## **FIRE RISK MANAGEMENT, INC**

# **Memo Report**

**Subject: Fire Protection and Life Safety Systems Review; ICW Renovation of the Westin Eastland Park Hotel in Portland, ME**

**GROUND & 2ND LEVEL LIFE SAFETY PLANS**

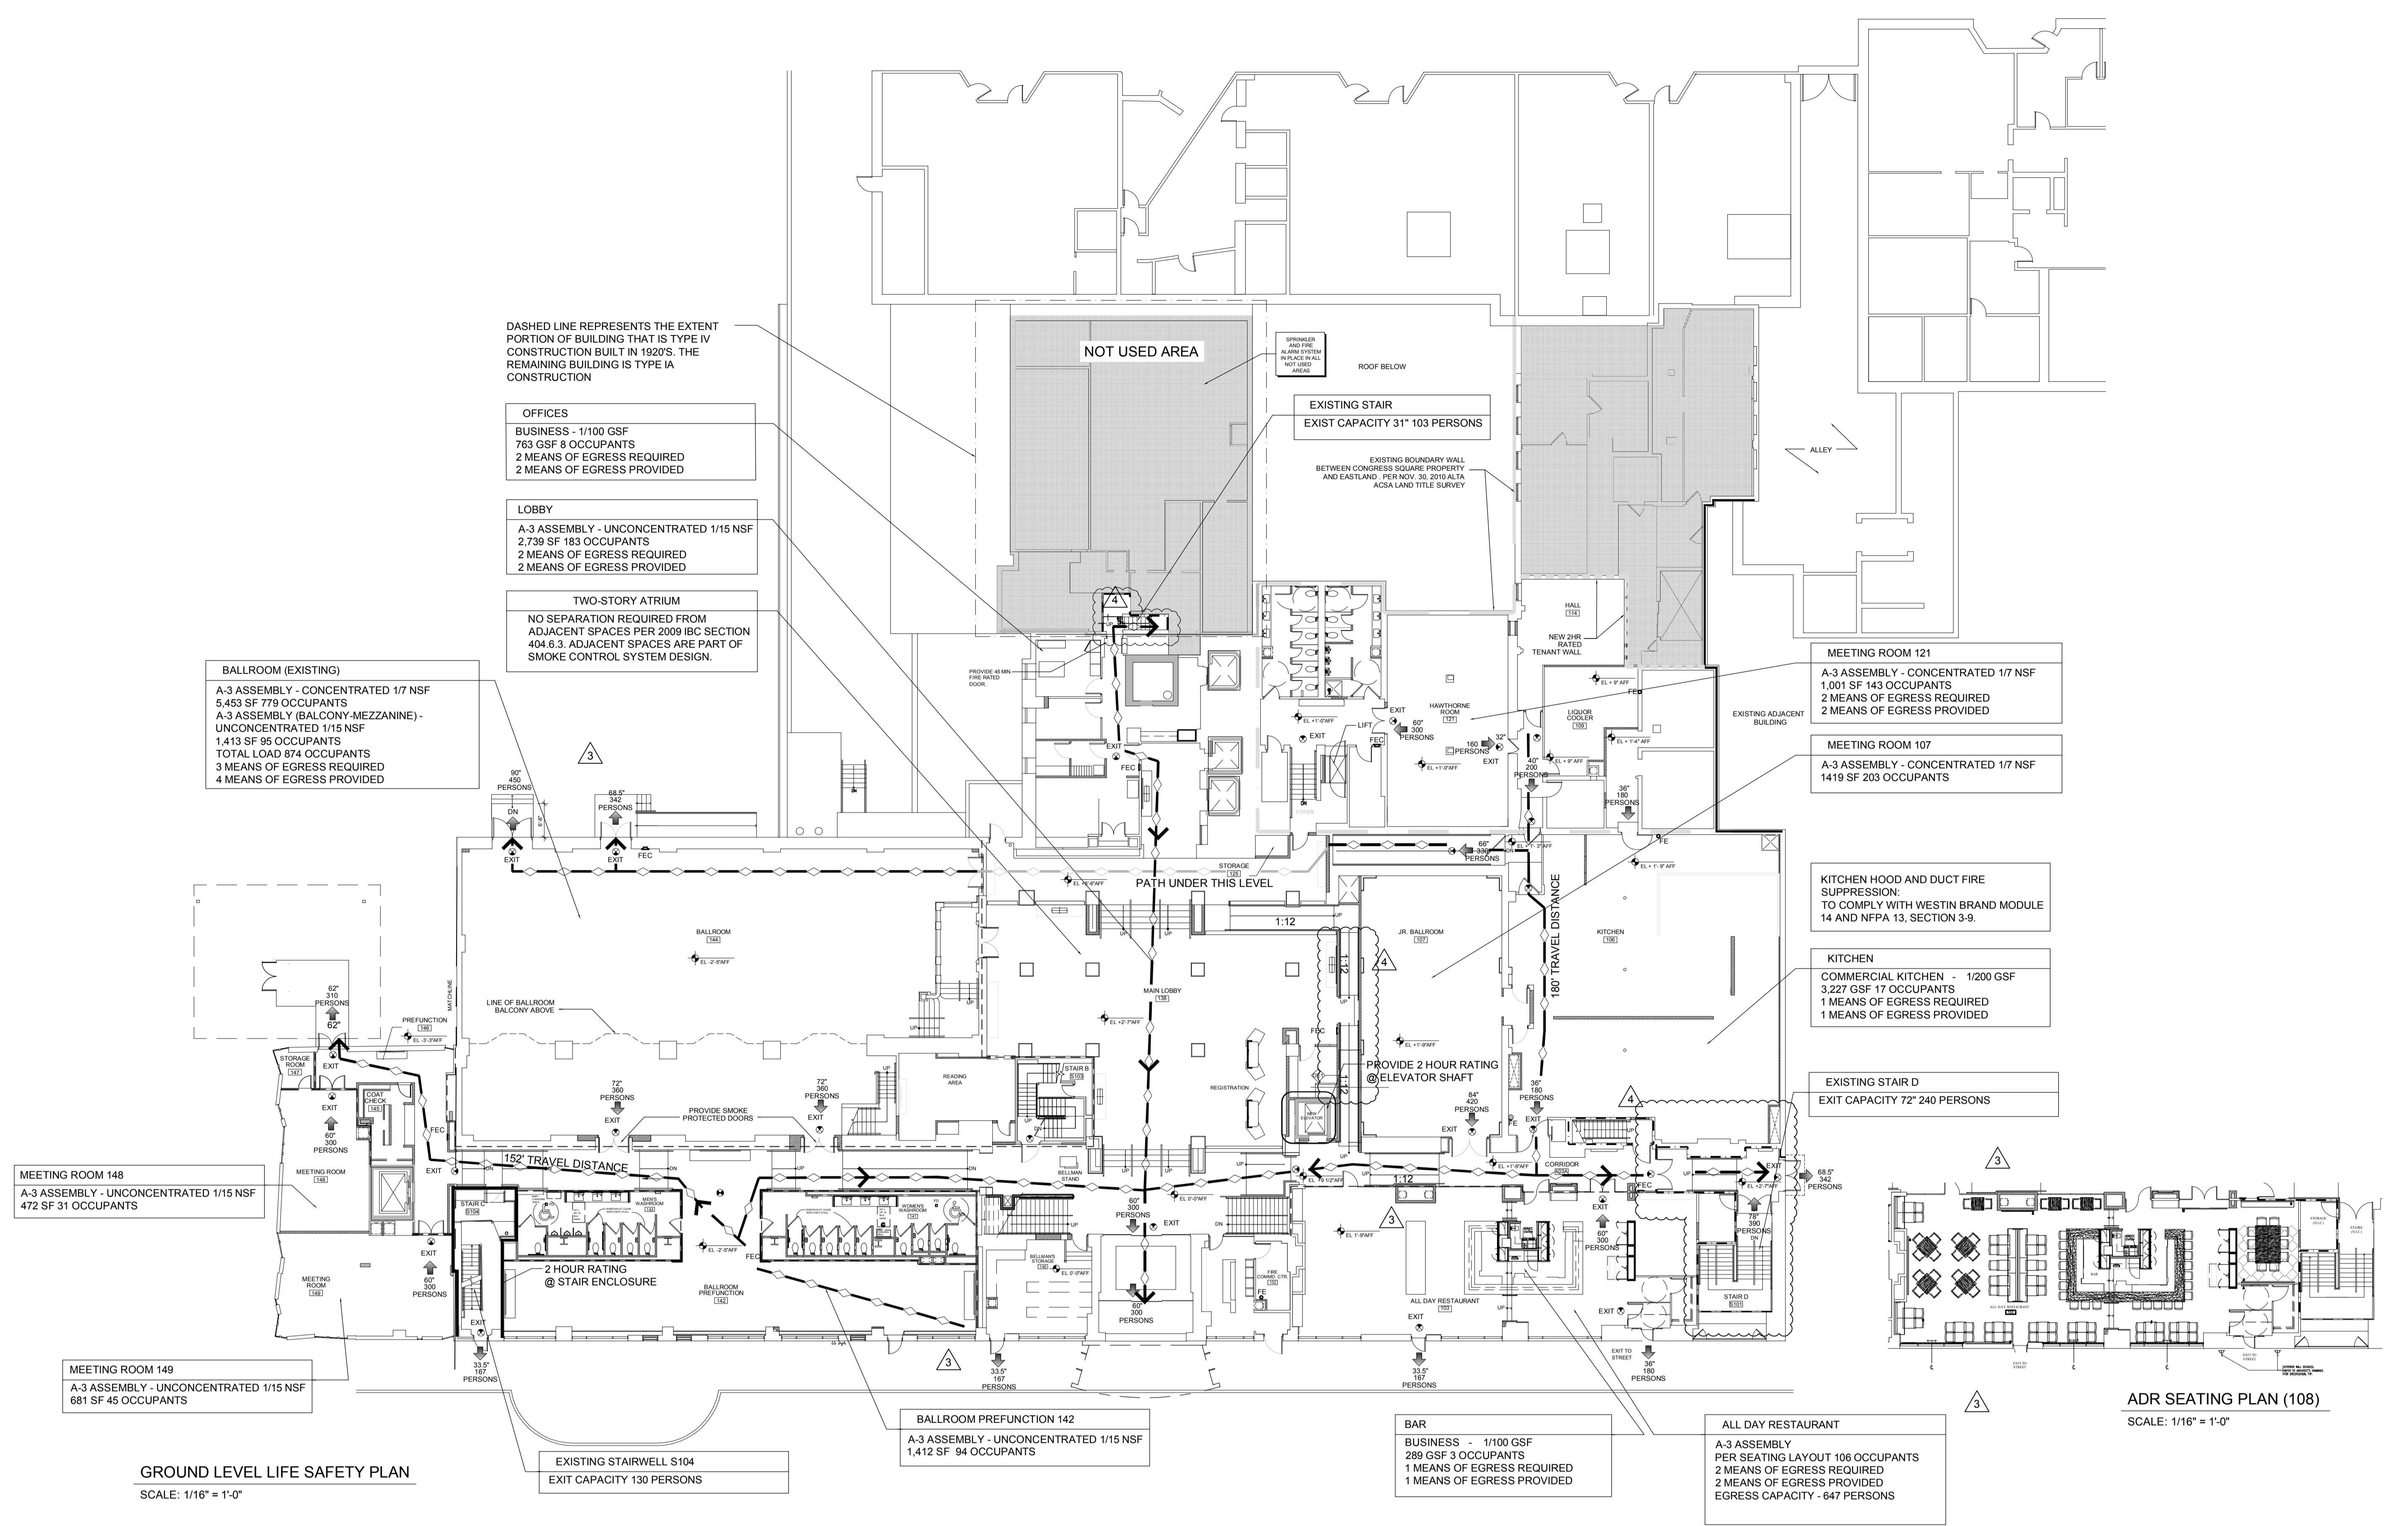
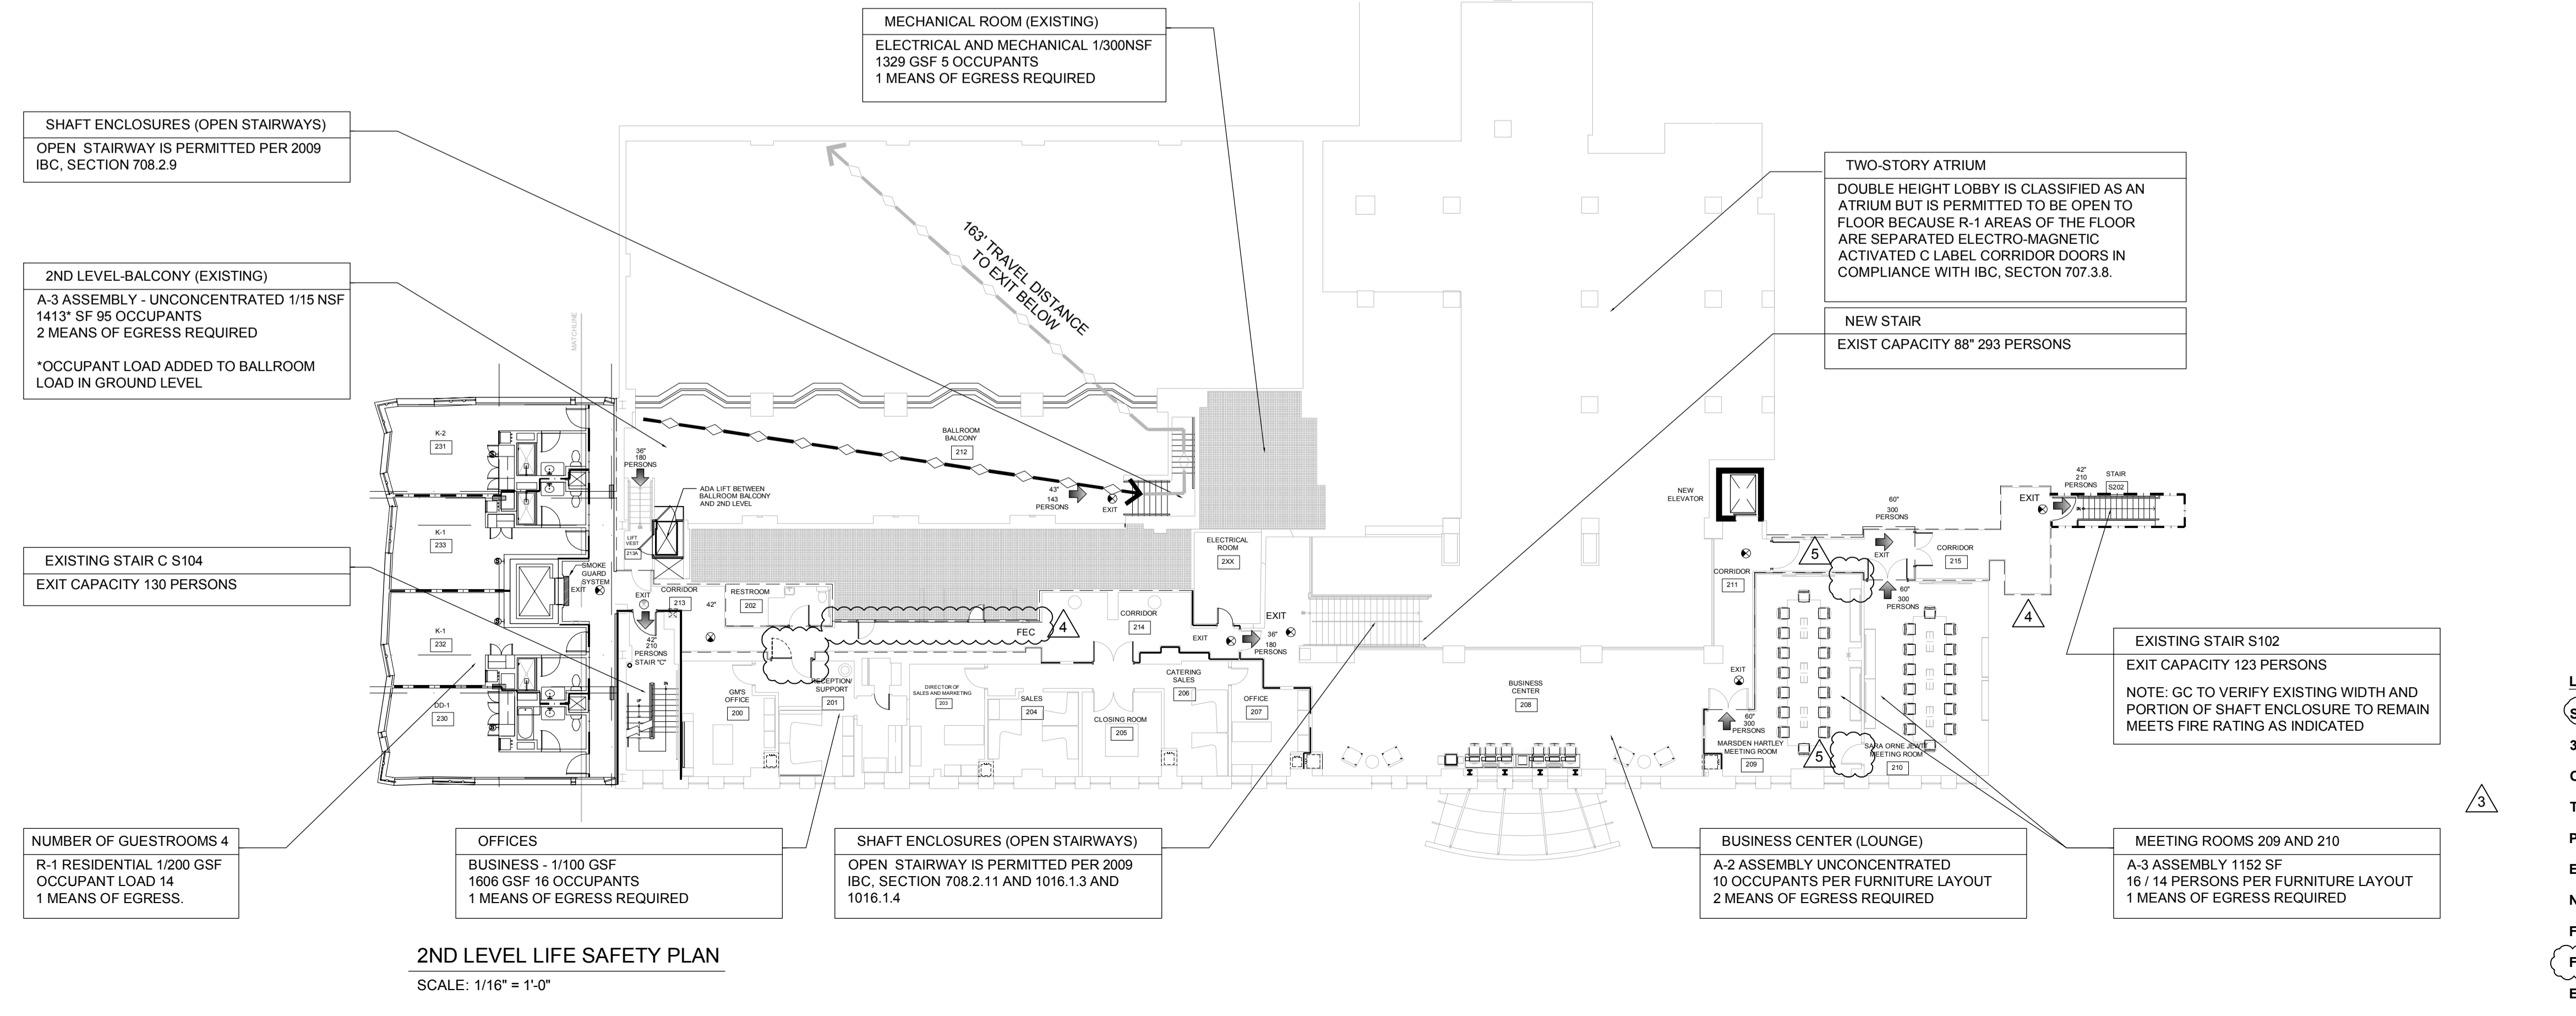
1. Need to add an exit sign within the "Prefunction" area at the 1<sup>st</sup> floor; adjacent to the exit door leading to the exterior, adjacent to High St.
2. Need to add an exit sign at the end of the ramp/corridor that acts as the second means of egress from the Junior Ballroom, connecting this room to the corridor adjacent to the ADR.
3. Need to relocate the exit sign that is adjacent to the Kitchen's exit door and that leads to the service corridor for the Ballroom. This corridor also acts as a second means of egress from the Hawthorne (conference) Room and the current location of the exit sign is confusing. It should be moved to the center of the corridor and be

designed such that it can be viewed from both the Kitchen side and the corridor from the Hawthorne Room; with arrows (chevrons) pointing in the direction of the Ballroom.

As soon as each item was identified during this final survey, IDC took immediate action to implement the necessary corrective actions.

14TH FLOOR LIFE SAFETY PLAN  
SCALE: 1/16" = 1'-0"

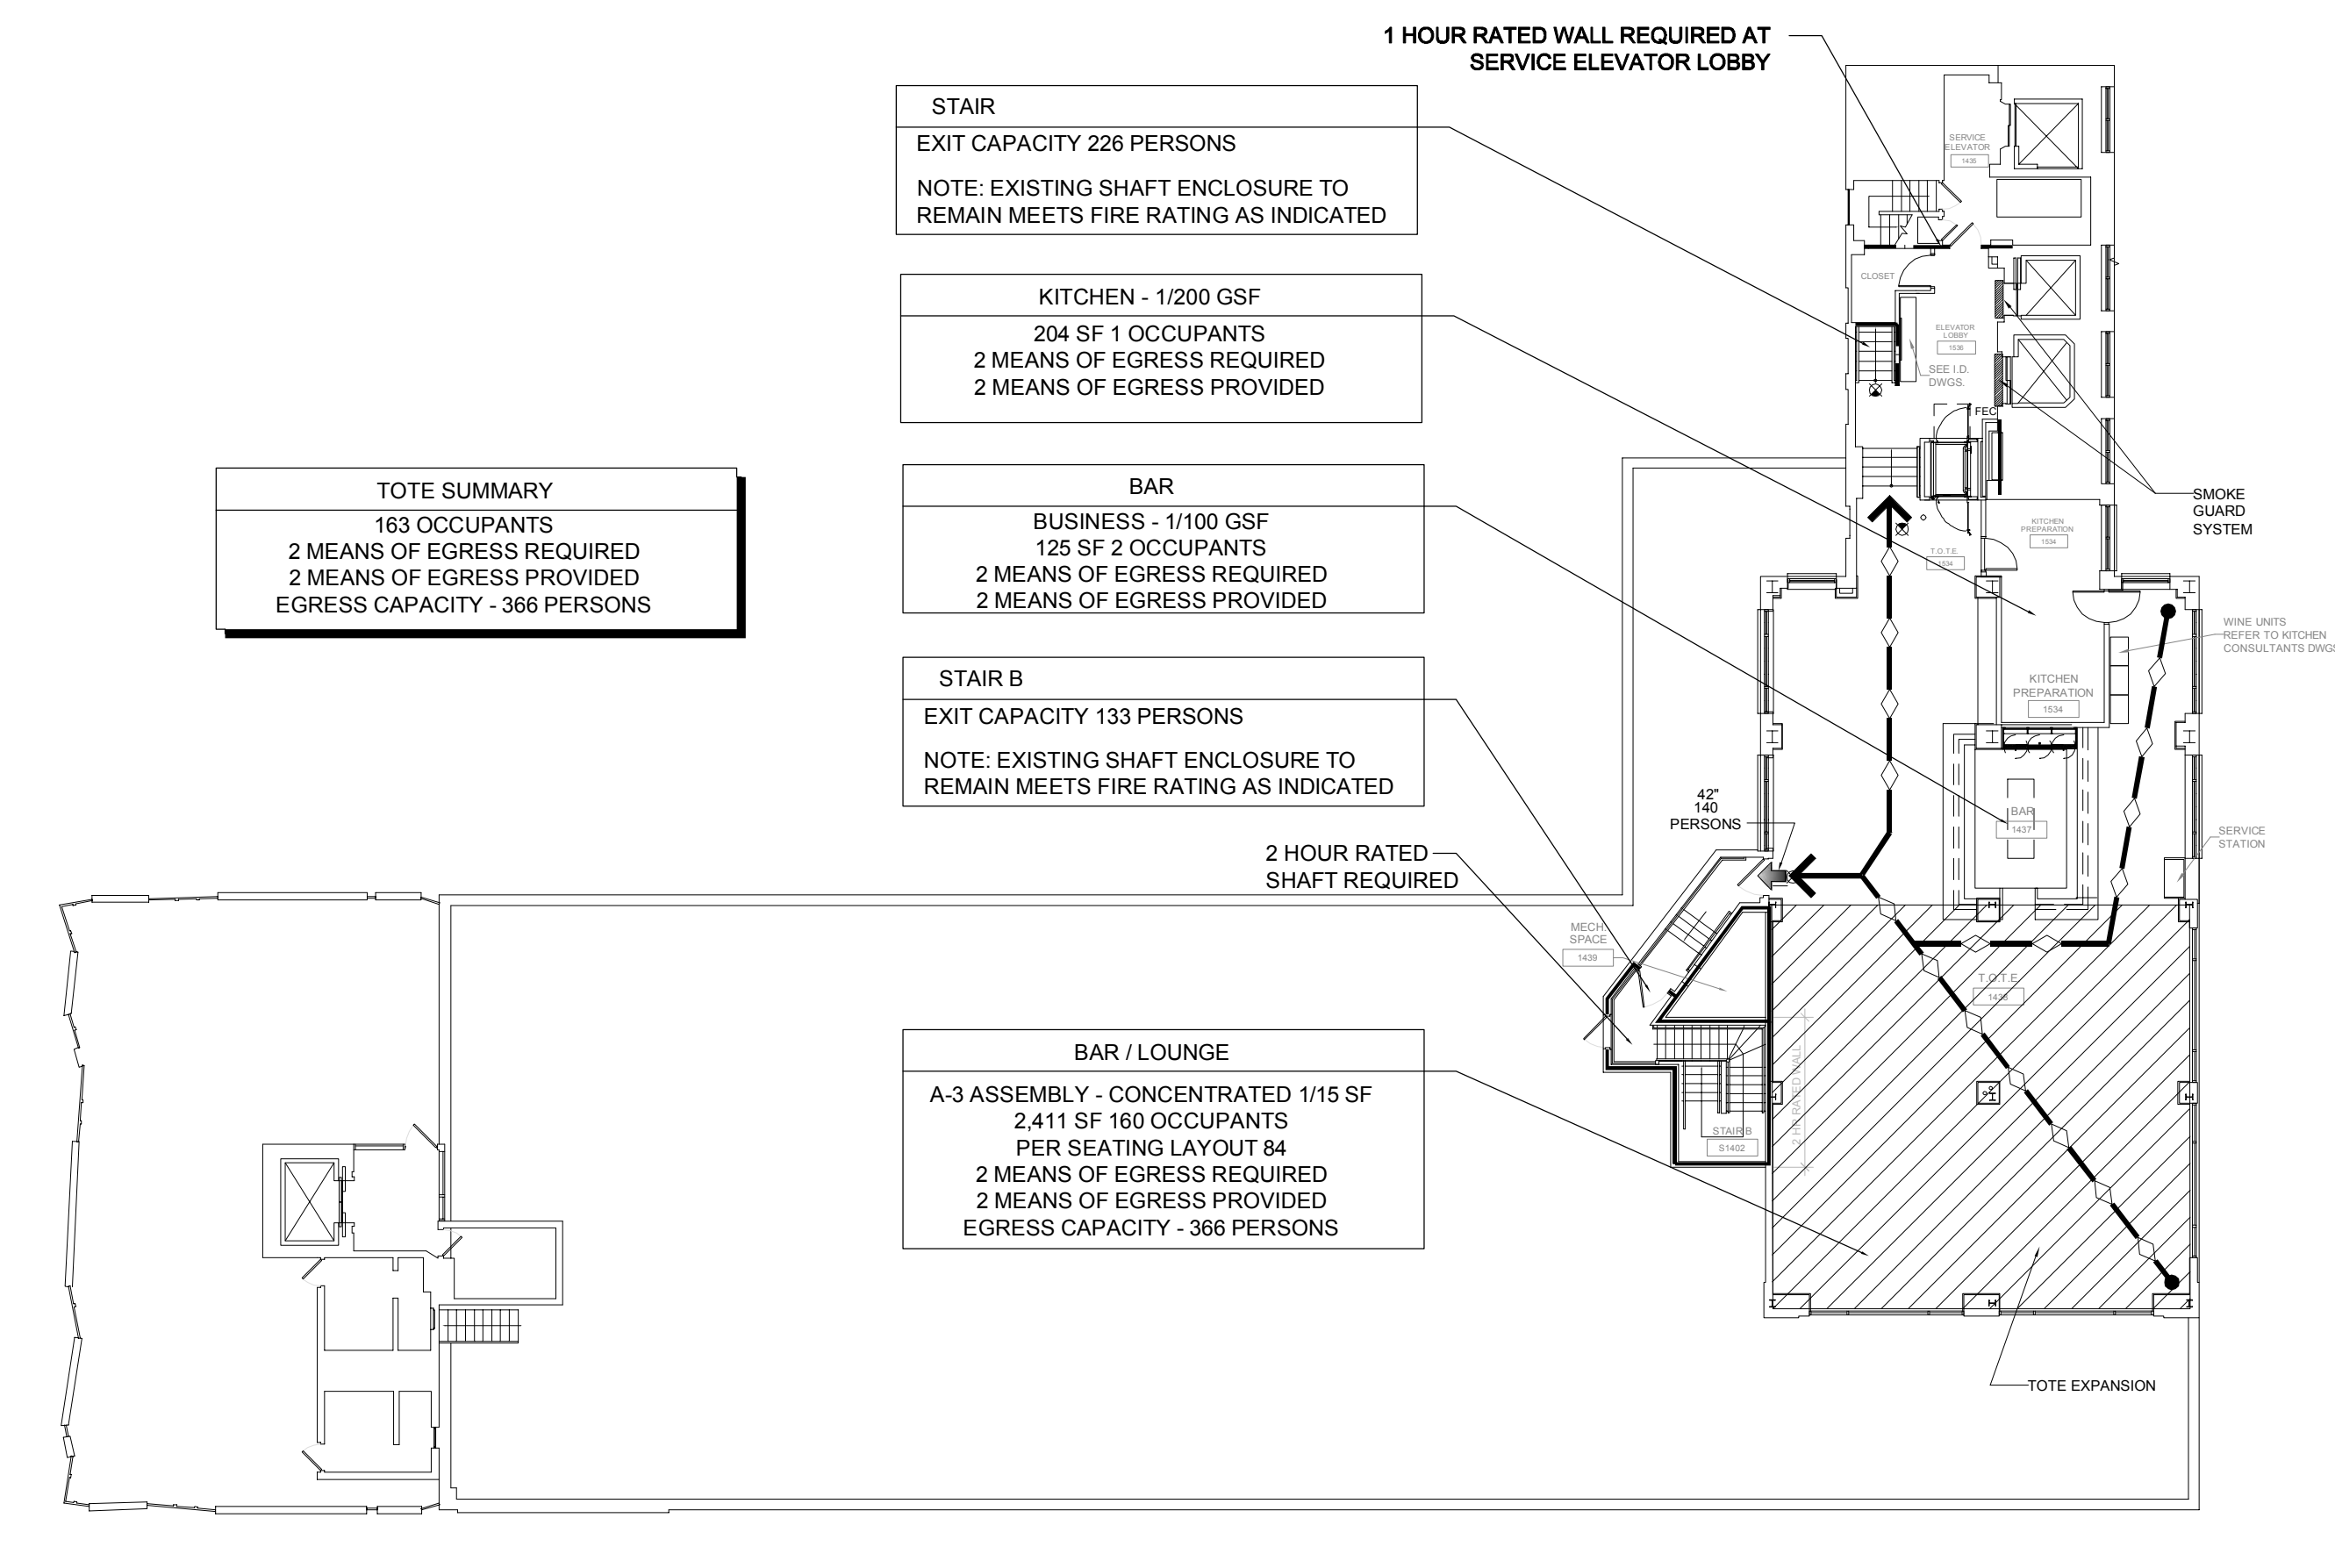
4. Provide continuity of the railing design for the stairway leading from the TOTE to the 14<sup>th</sup> floor to ensure that no gap in the railing exceeds 4 inches.
5. Provide continuity of the railing design at the 1<sup>st</sup> floor level of Stair B to ensure no gap in the railing exceeds 4 inches.
6. An exit sign should be added to the inside of the 1<sup>st</sup> floor door in Stair B to highlight the fact that this is the level of exit discharge for this stair.
